Engineers Comments Regarding Surface Water Drainage

Application Reference:	AL/6/25/DOC	Reviewer Reference:	ADC/SB & PC
Planning Officer:	Hannah Kersley	Date of Review:	26/08/2025
Site Name:	8 Autumn Gate Hook Lane Aldingbourne PO20 3TE		
Application Description:	Approval of details reserved by condition imposed under reference AL/75/24/HH relating to condition number 4 - surface water drainage scheme.		
Assessment Number:	1 of 2

Condition 4: Objection

PROPOSED DRAINAGE STRATEGY (scale 1:100)

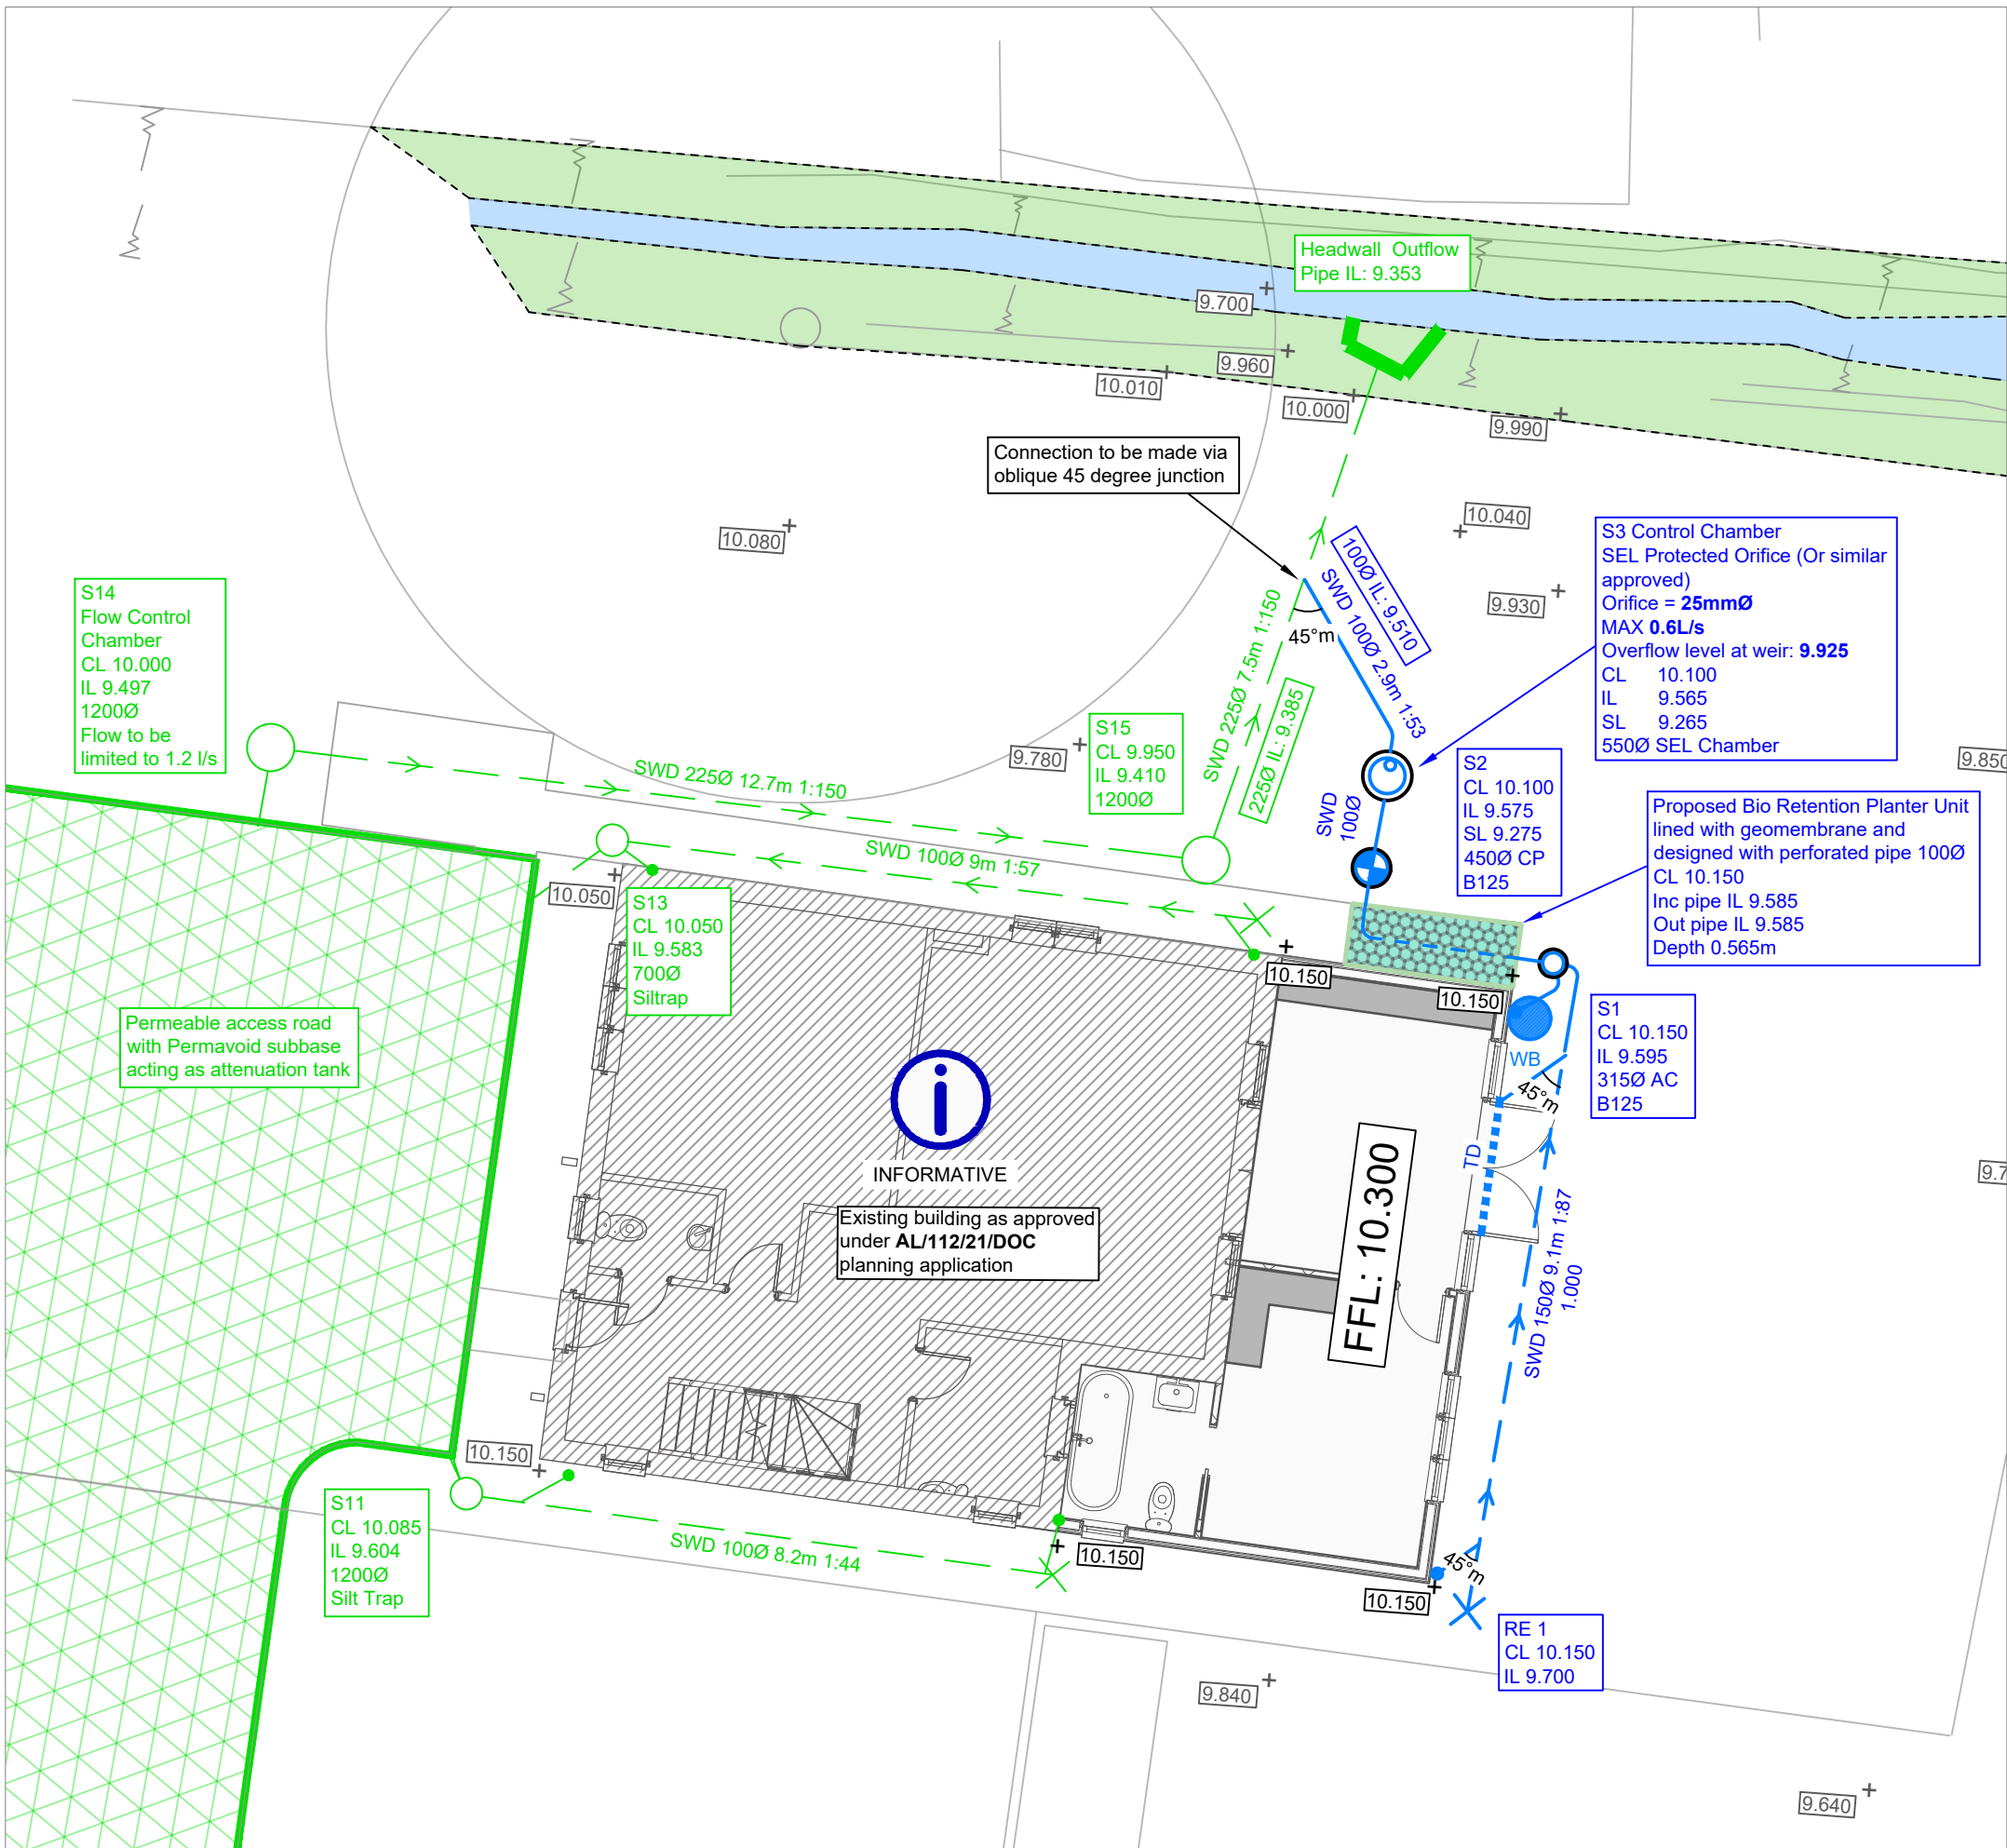
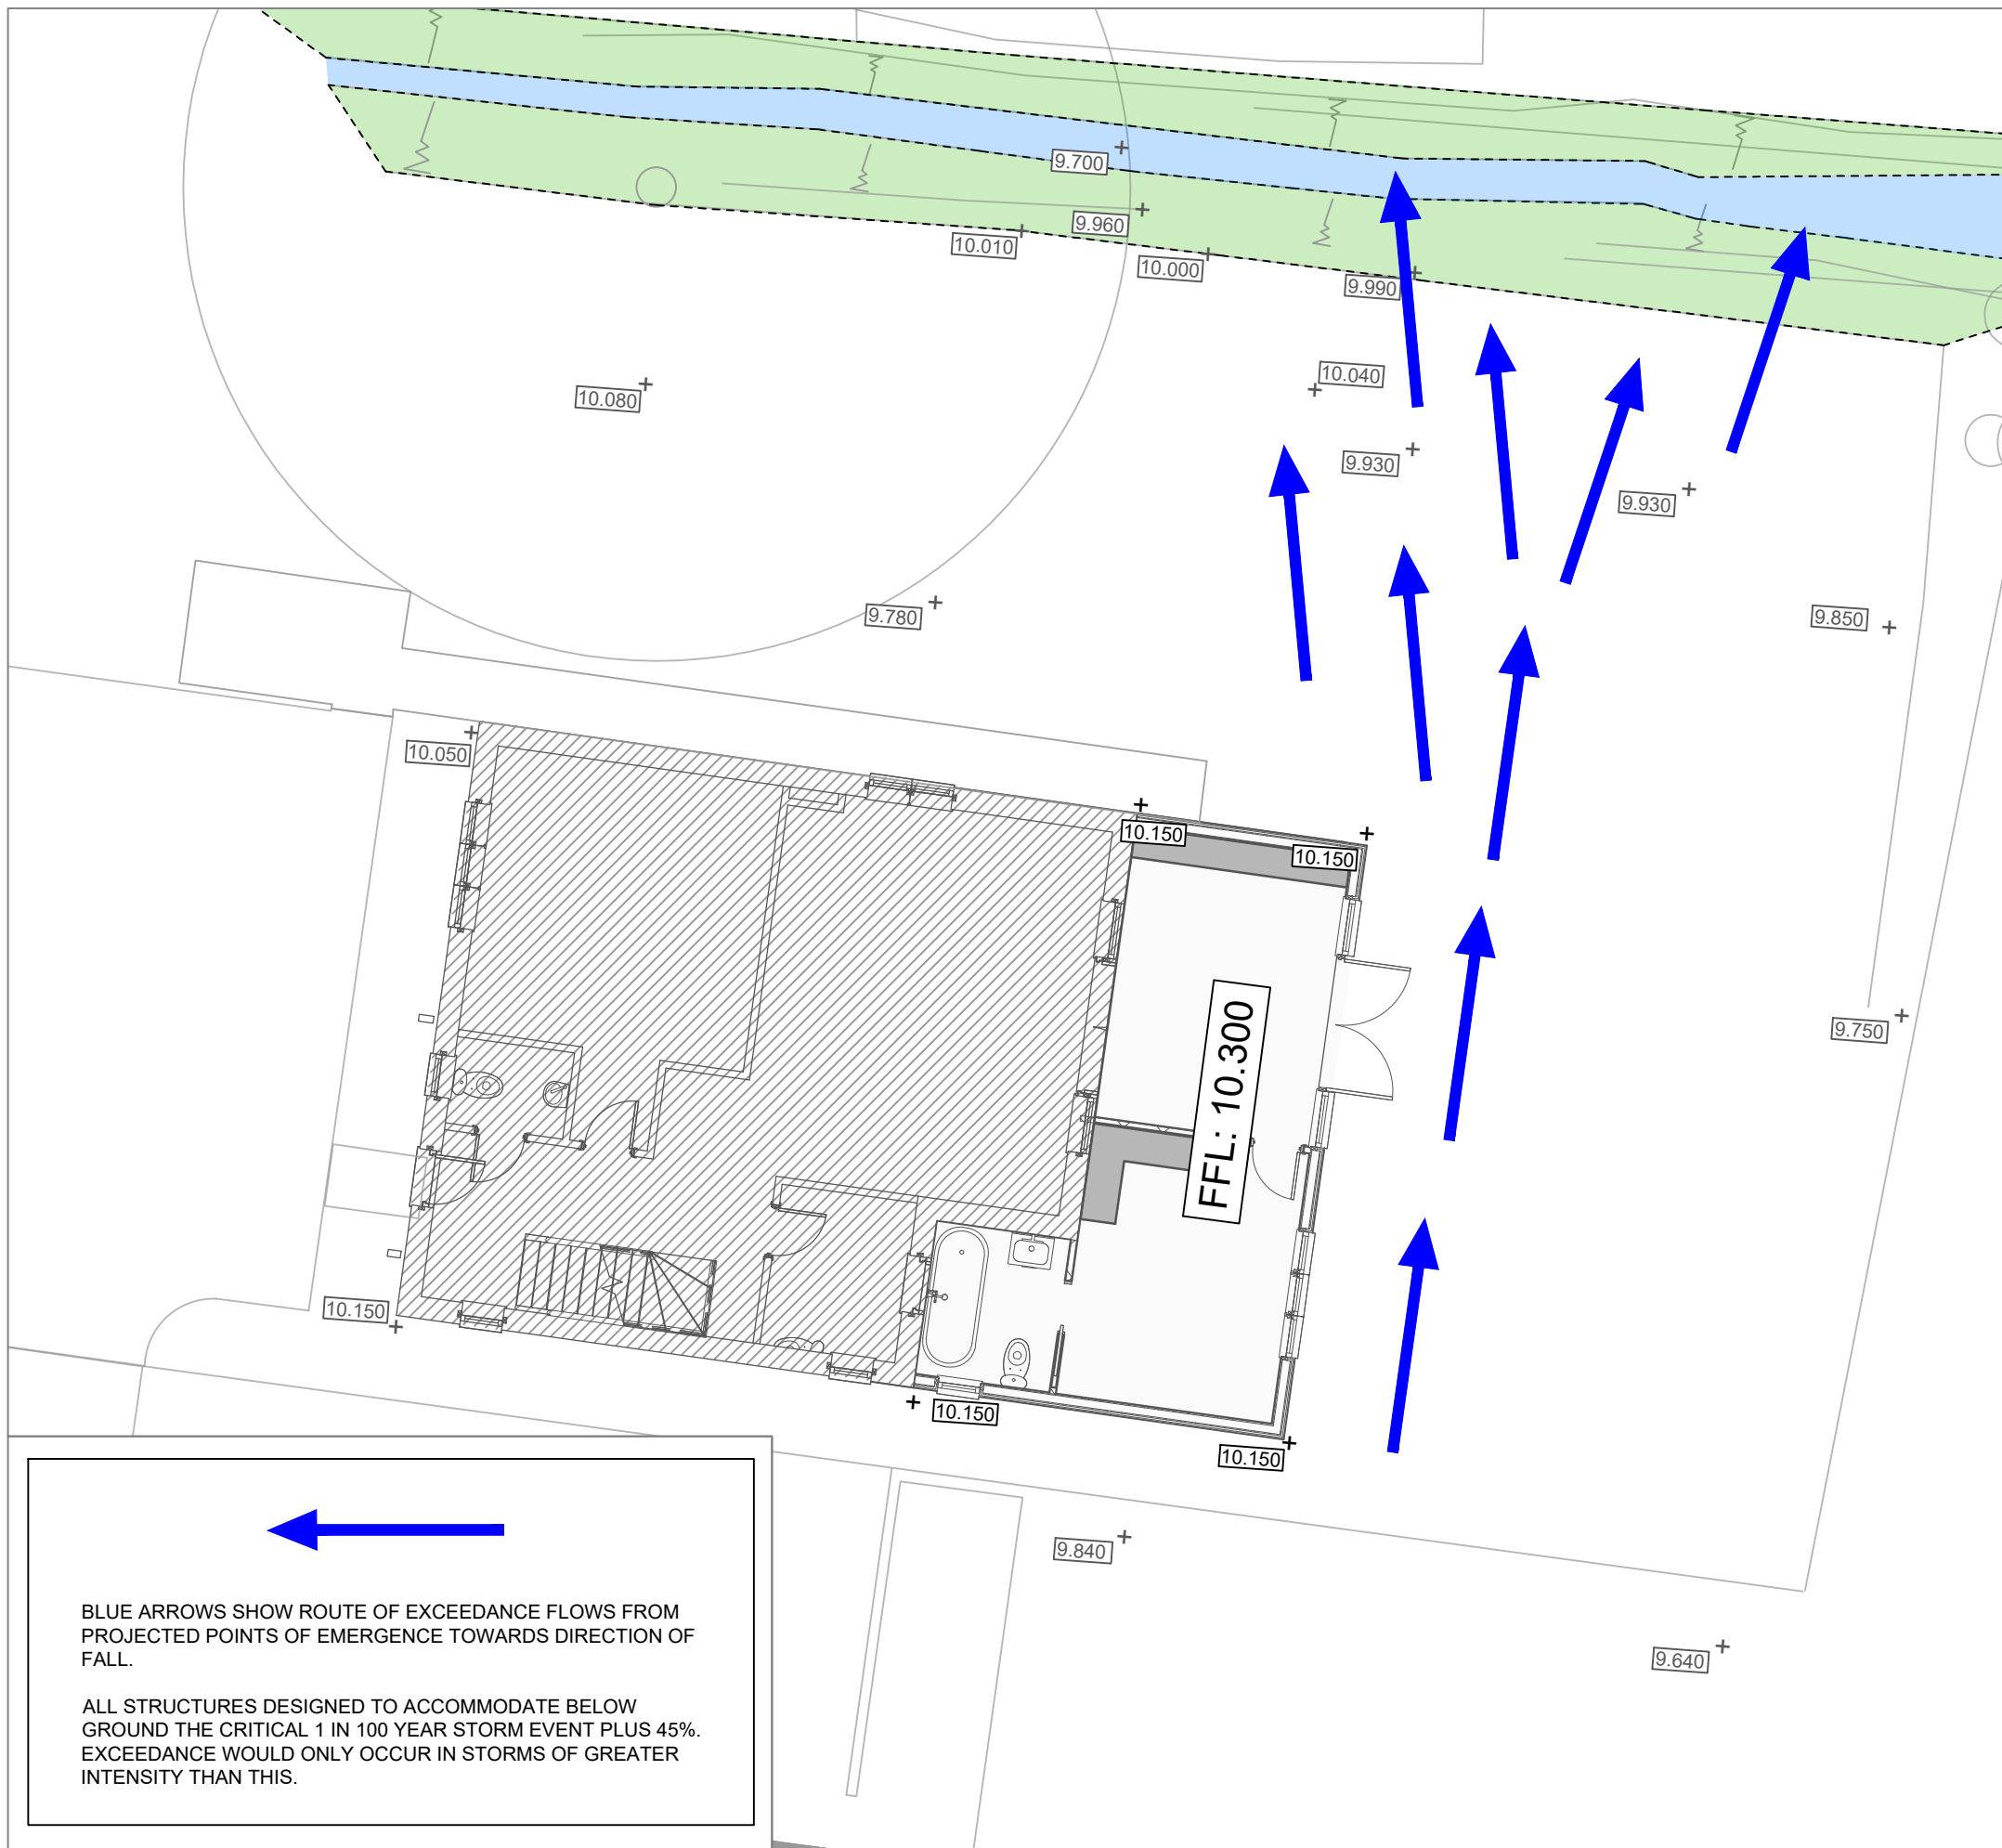
3.	Where the existing pipe is being connected to, specify an oblique 45 degree junction or new manhole.	Updated. The oblique 45 degree ensured.	Please advise where the drawing has been updated to reflect this.

6.	Specify orifice diameter on drainage layout plan.	Updated.	Noted. Comment closed.

7.	Where the threshold drain is being connected to pipeline Re1 to S1, specify an oblique 45 degree junction. Similar comment for the RWP on the SE corner.	Updated.	Clearly indicate that these connections will be made using oblique 45 degree junctions.

ACO Threshold Drain
(scale 1:20)

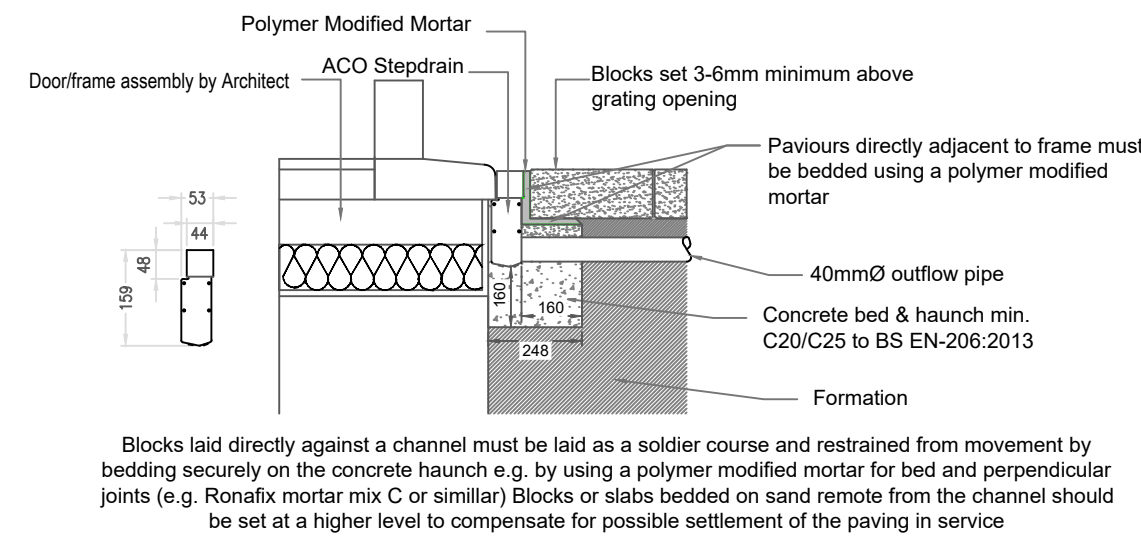
10.	Fully detail the Aco Threshold Drain construction detail ie. fully dimension/specify the channel, dimension bedding.	Updated.	Noted. Comment closed.

Rodding eye detail
(scale 1:20)

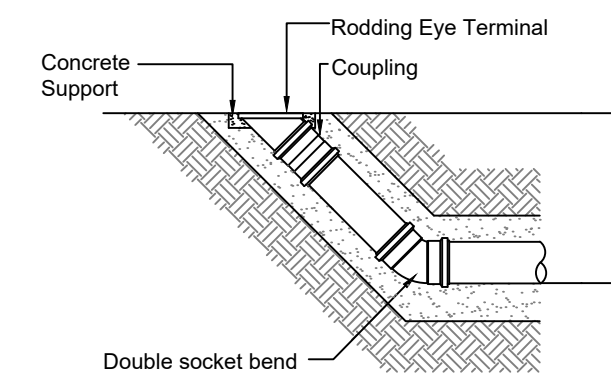
8.	Provide rodding eye construction detail.	Updated.	Noted. Comment closed.		
9.	Sel Contraflow 500 Orifice chamber – specify overflow level at weir.	Updated. Overflow level at weir 9.925	Noted. Comment closed.

450mmØ/600mmØ Turtle Enviro Silt Trap Detail
(scale 1:20)

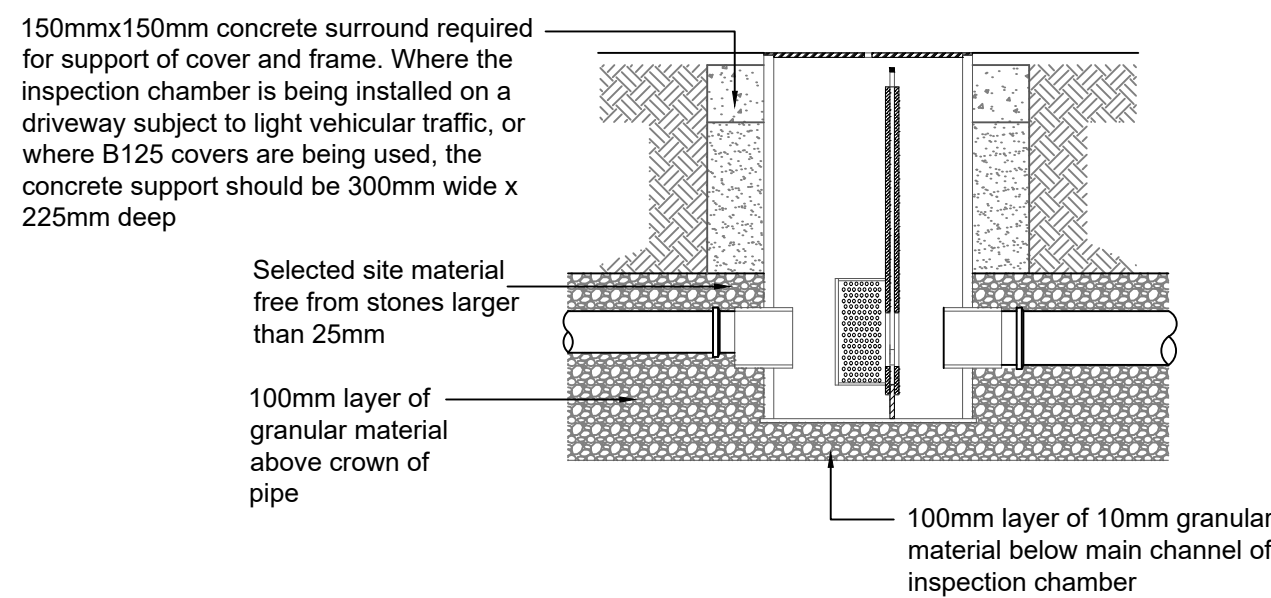
5.	Provide a suitable catchpit upstream of the flow control chamber, ensuring all flows have to pass through this chamber. Include full construction details.	Updated.	Specify sump depth on construction detail.

Typical BIO Retention Planter Detail
(not to scale)

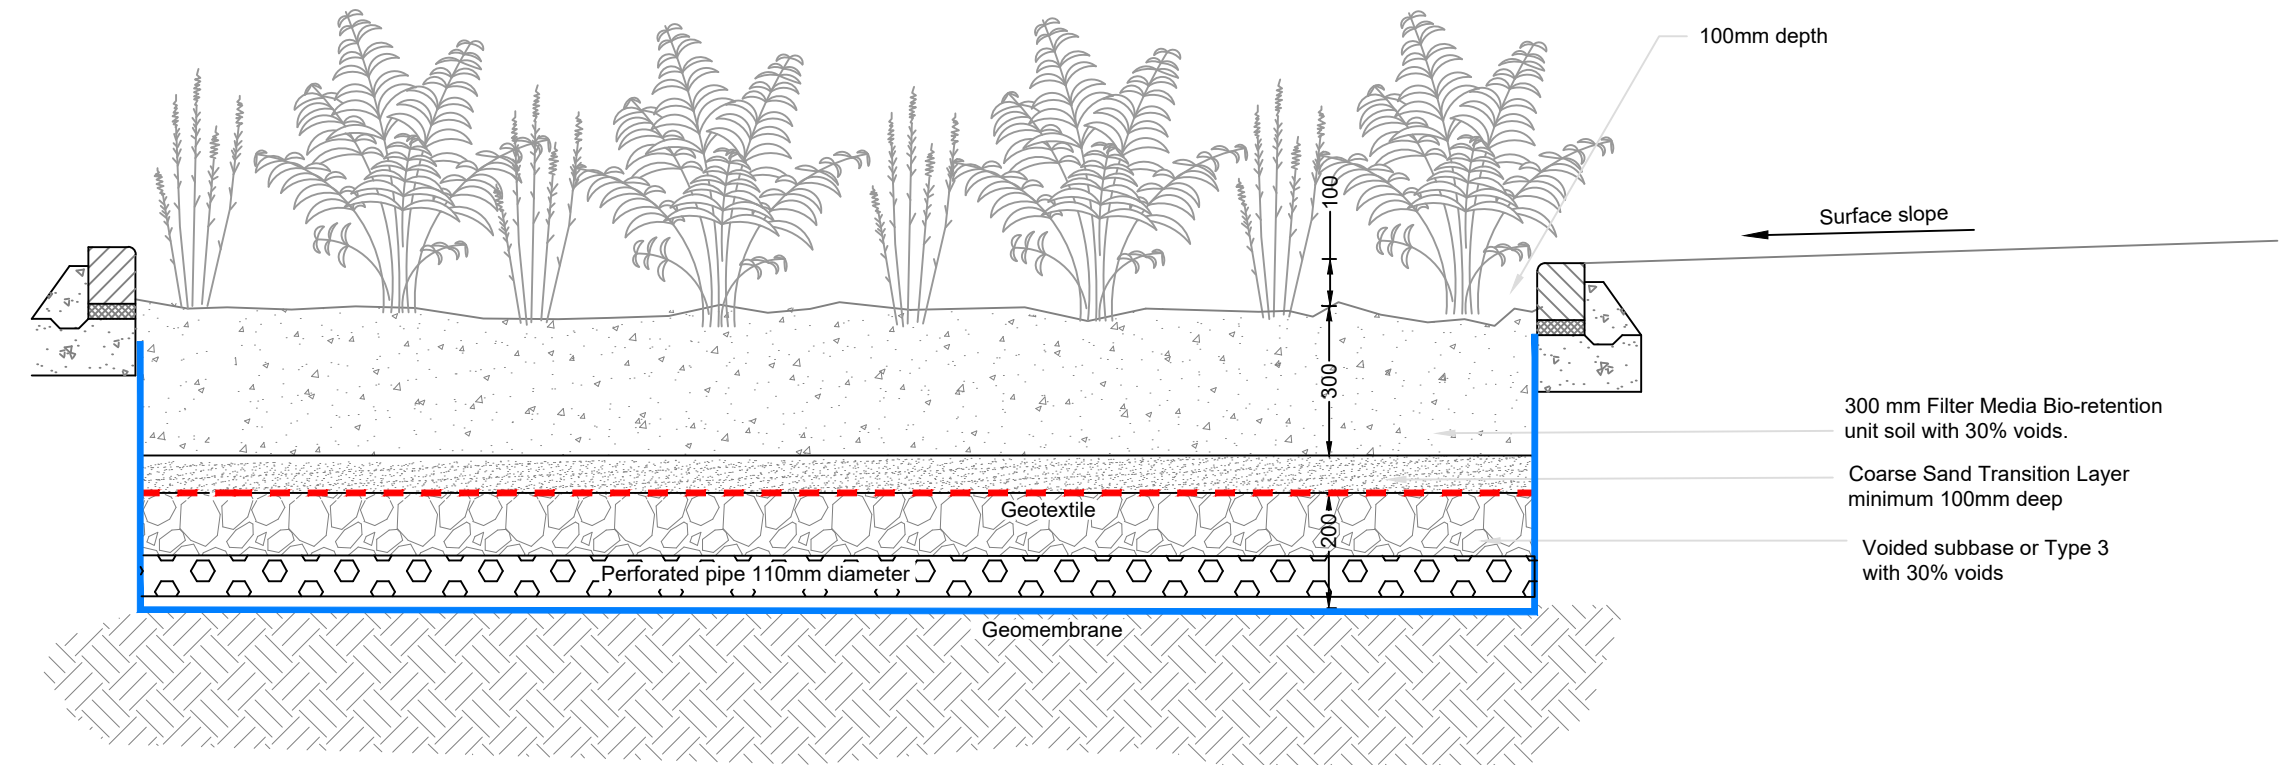
4.	Please provide interception drainage to ensure that the first 5mm of rainfall over the proposed impermeable area is not discharged from the site. I.e. rainwater harvesting, etc.	A water butt will be provided to capture the first 5mm of rainfall, in line with the interception drainage requirement.	Water butt proposed to serve part of roof only. However, Standard 2 of the National Standards advises that water butts do not achieve the interception requirements, unless they can be demonstrated to comply. Please review. Full construction details will be required to support any proposal.
